Planning Application Ref: WA/93/21/PL

Location: Land adjacent to Oak Bank, Wandleys Lane, Walberton, BN18 0QR

Description of works: New detached dwelling & detached garage. This site is in CIL Zone 3 & is CIL Liable as new dwelling. This application is a departure from the Development Plan

Site Block Plan 1:200

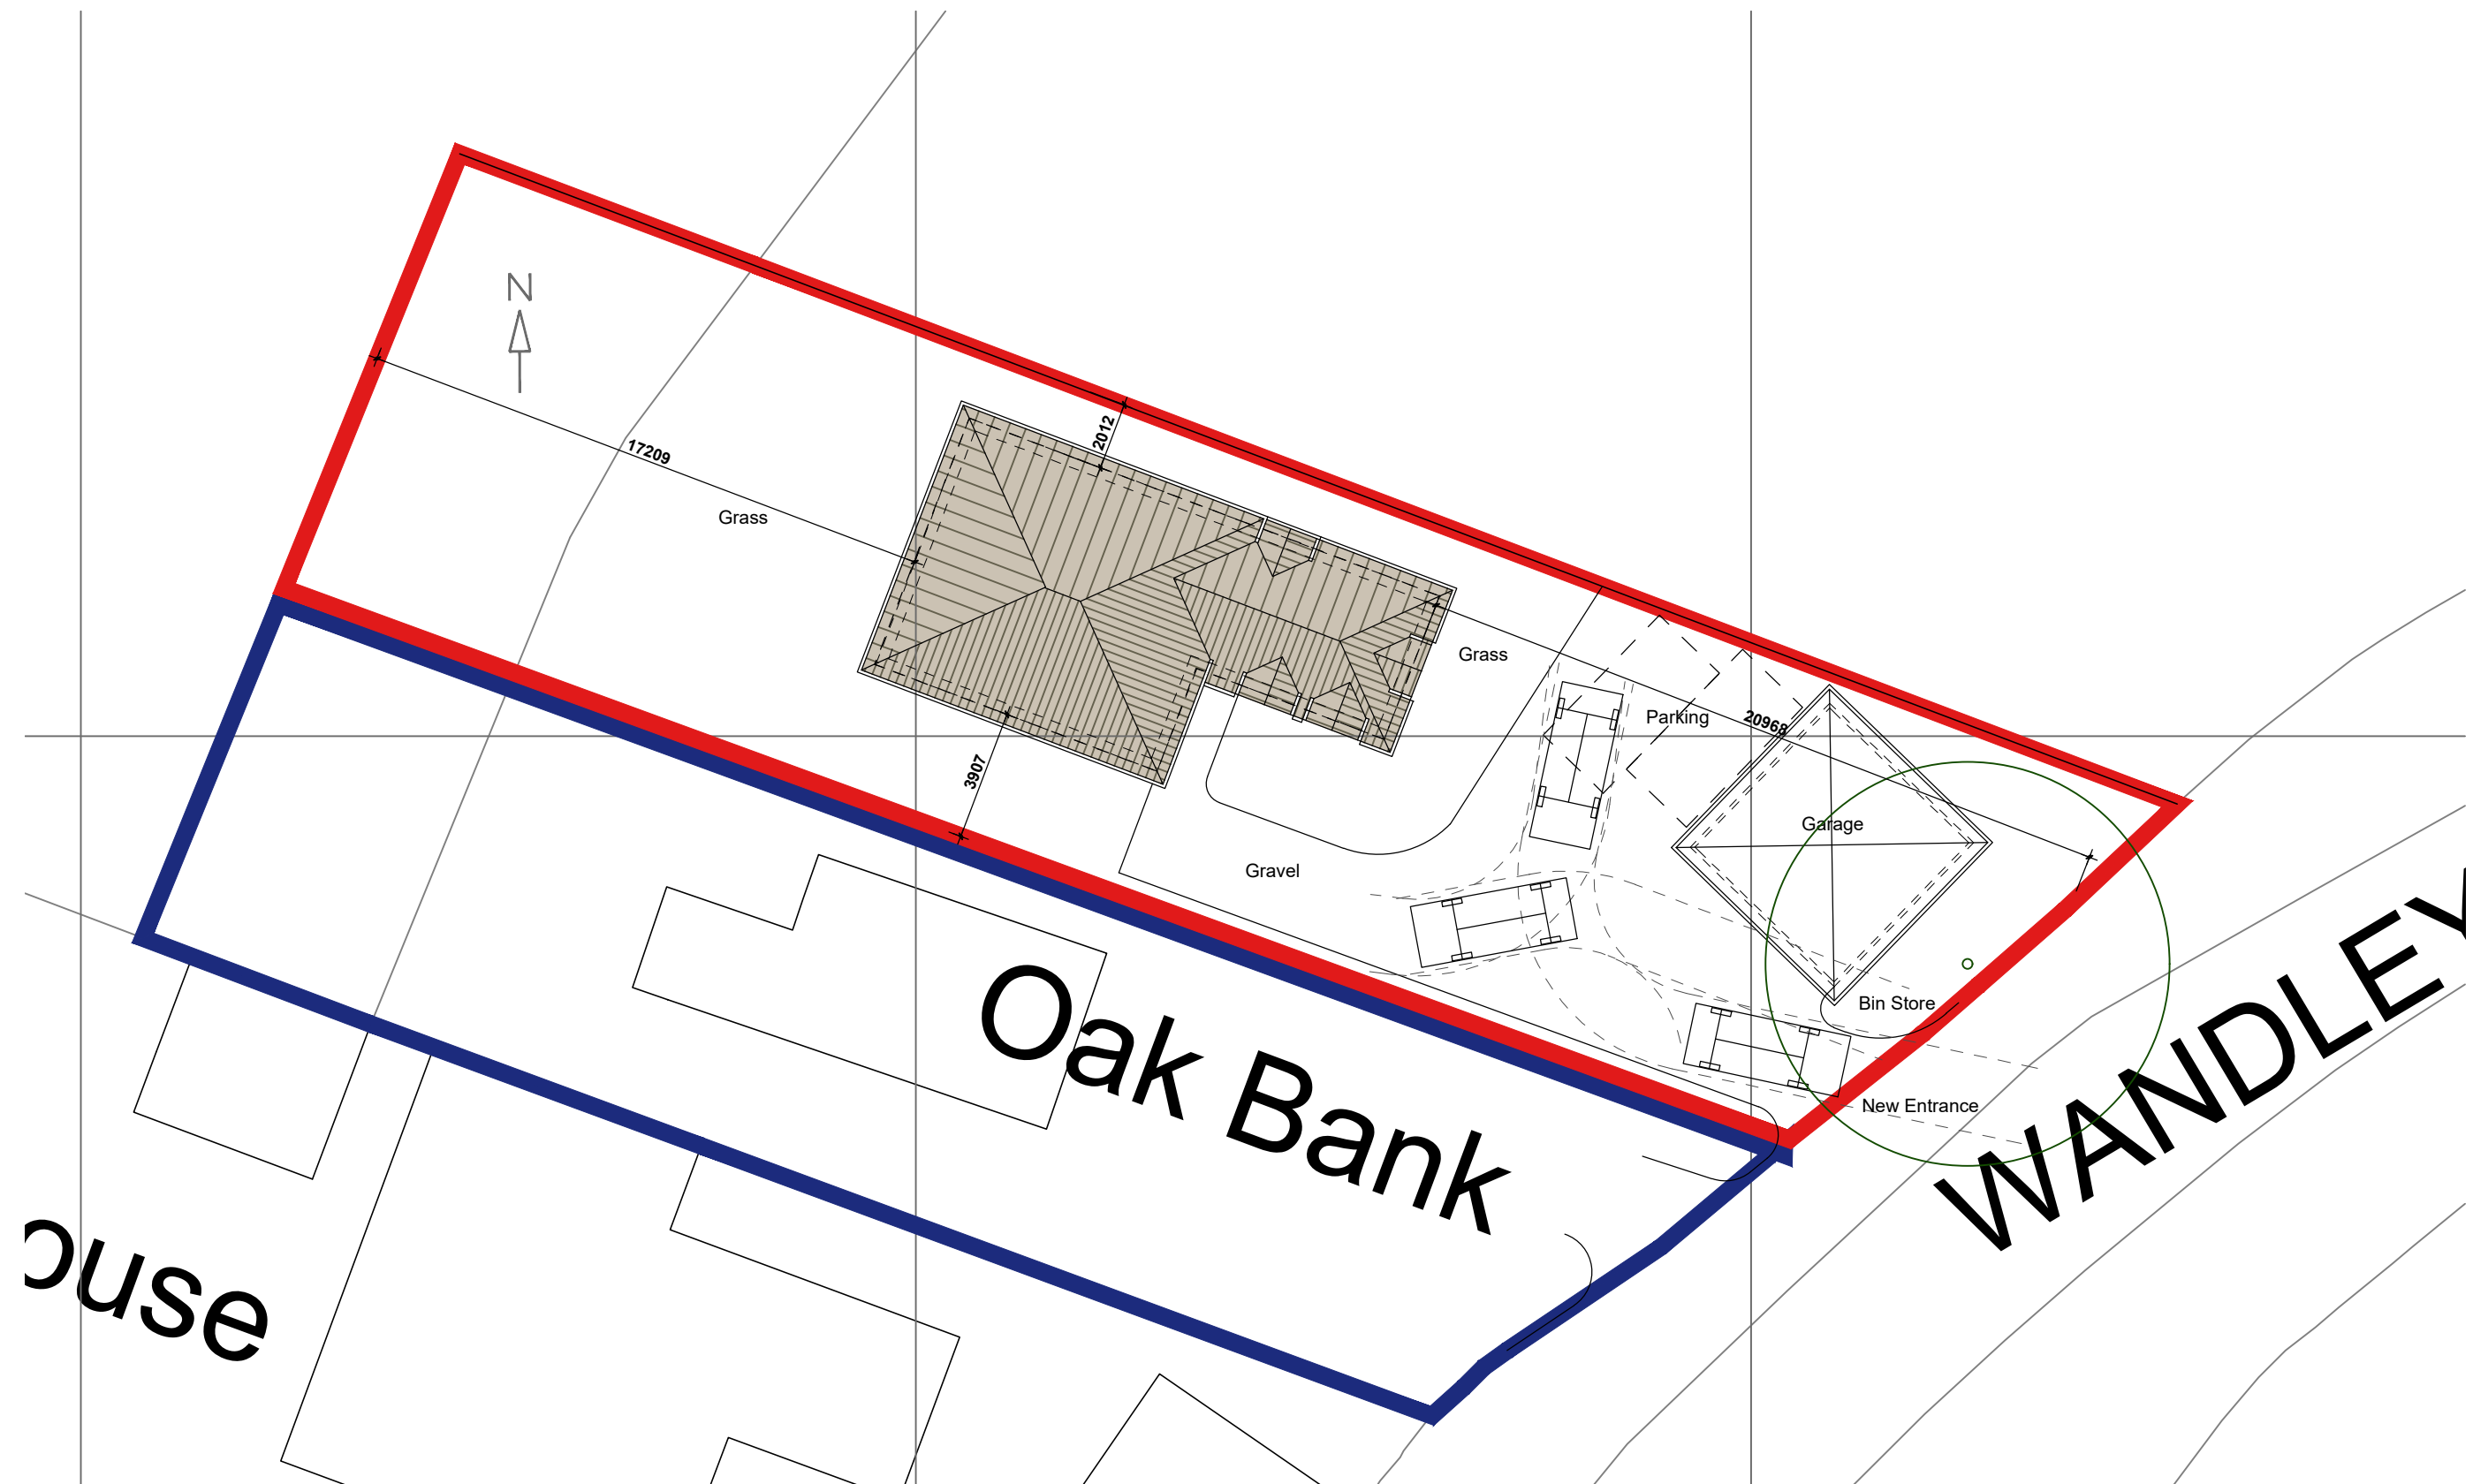
- Until such time as we have plans showing detailed layout and position of services, overlaid with accurate tree data (root and crown spread shown), it is not possible to adequately understand what the relationship between built form and green infrastructure is likely to be.

- It is already clear that the aforementioned oak will be negatively impacted by the introduction of; new vehicle access, garage structure and likely enhancement of existing watercourse to meet surface water drainage requirements.

- A sympathetic and high-quality development of this site may be achievable without undue detriment to retained on and off-site trees, although we are yet to have sight of the necessary arboricultural report and plans to demonstrate this has been properly considered - or is even an aspiration given the proposed Block Plan and Design and Access Statement.
- As it stands, I recommend **REFUSAL** of this application.

- If the application is allowed to progress, I strongly recommend (prior to a decision) the applicants be required to employ the services of an Arboricultural Consultant to carry out a tree survey exercise and then prepare an Arboricultural Impact Assessment (AIA) which must be inclusive of; a 'Tree Survey Schedule', a 'Root Protection Area (RPA) Schedule' and a 'Tree Constraints Plan' – with the trees accurately plotted on same, for our consideration.
- In the event that a RPA of any tree which is proposed for retention overlaps the development then BS5837:2012 requires that the Detailed Planning Application is accompanied by an Arboricultural Method Statement (AMS) and also most importantly a Tree Protection Plan – to both describe and illustrate the mitigation measures which are to be employed to ensure that the trees survive without
